Date: 09/16/2025

Re: **Damaged Roof Truss**
Location: Lot 135 Providence Creek (354 Providence Creek Dr. Fuquay-Varina, NC)
JDS Project No.: RDU2509679
Date of Inspection: 09/16/25

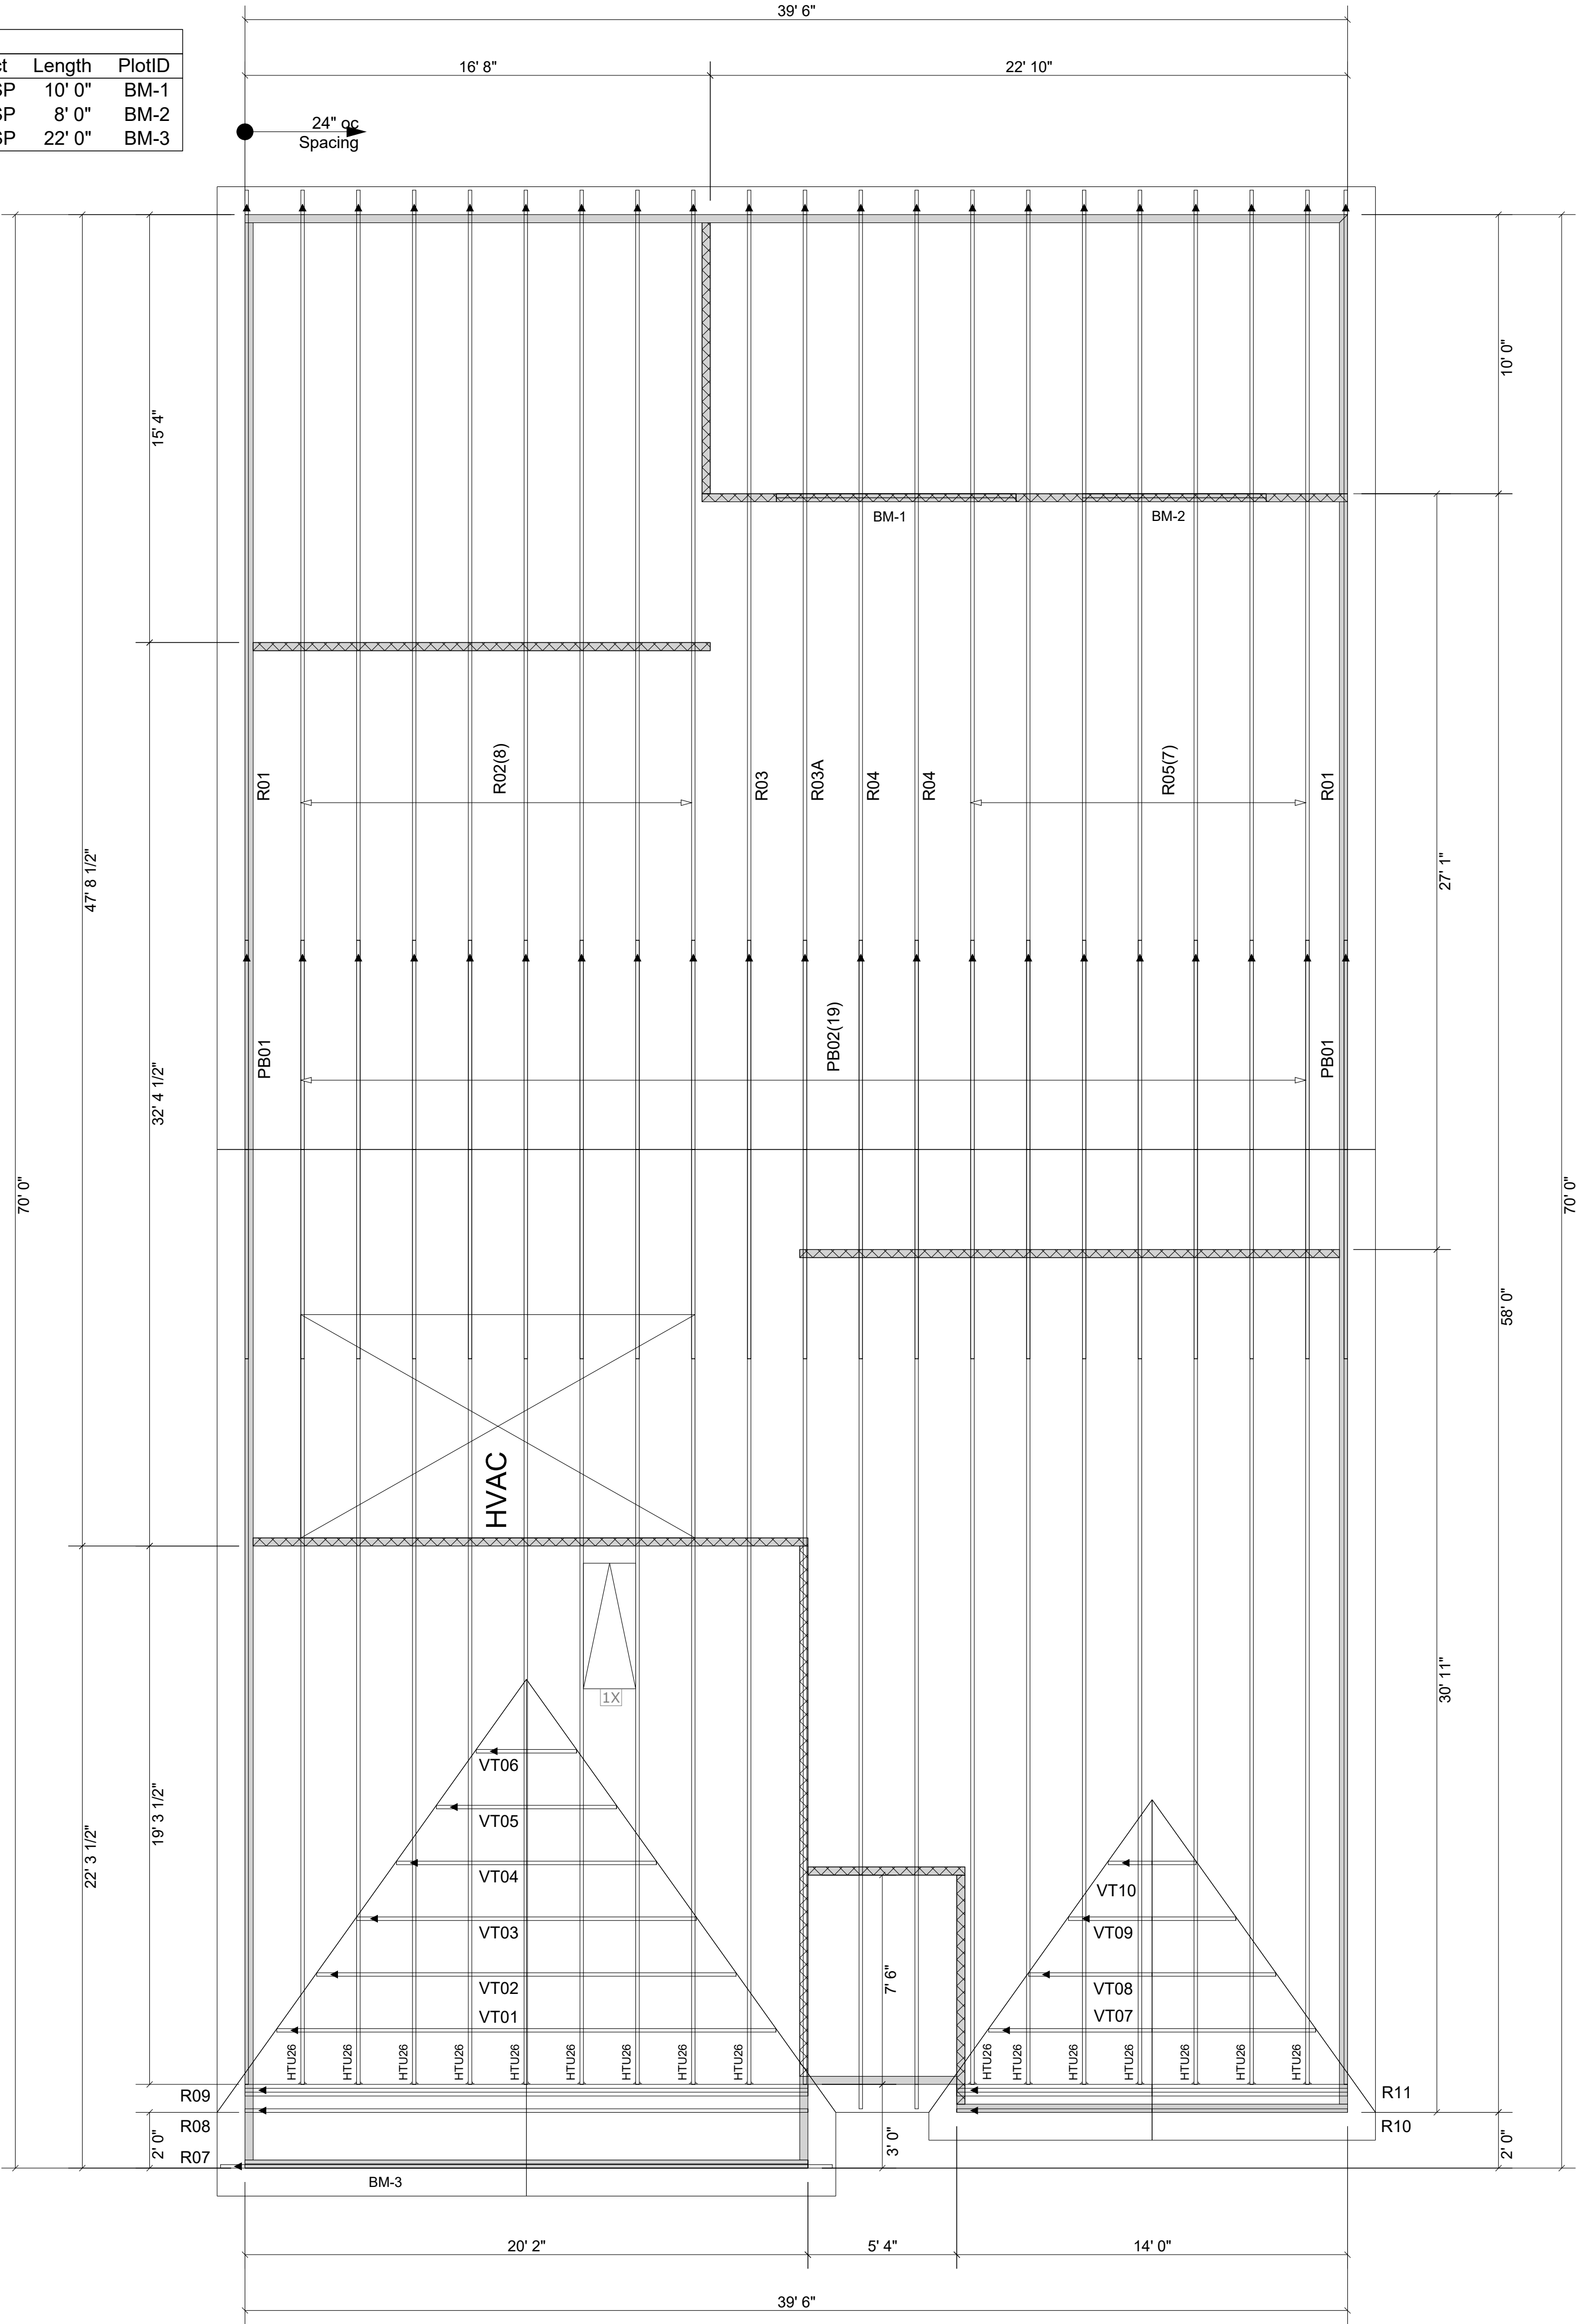
The client requests an evaluation of the 2nd roof truss from the left exterior wall. This truss has a missing web portion at the bottom chord of the 2nd diagonal web from the rear above the rear master bathroom wall.

1. Remove the gusset plates at the bottom chord.
2. Clean cut the remaining web portion.
3. Install a new full length (of the missing portion) web portion of equal or greater strength between the remaining portion and the bottom chord.
4. Attach the new web portion to the old web portion with a 4' long 2x4 scab on both sides centered on the meeting point with (2) rows of 10D nails spaced at 4" o.c.
5. Furr out the web and bottom chord as needed and install a 24"x24"x3/4" OSB gusset centered on the bottom chord gusset plate attached with (2) rows of 10D nails spaced at 4" o.c.
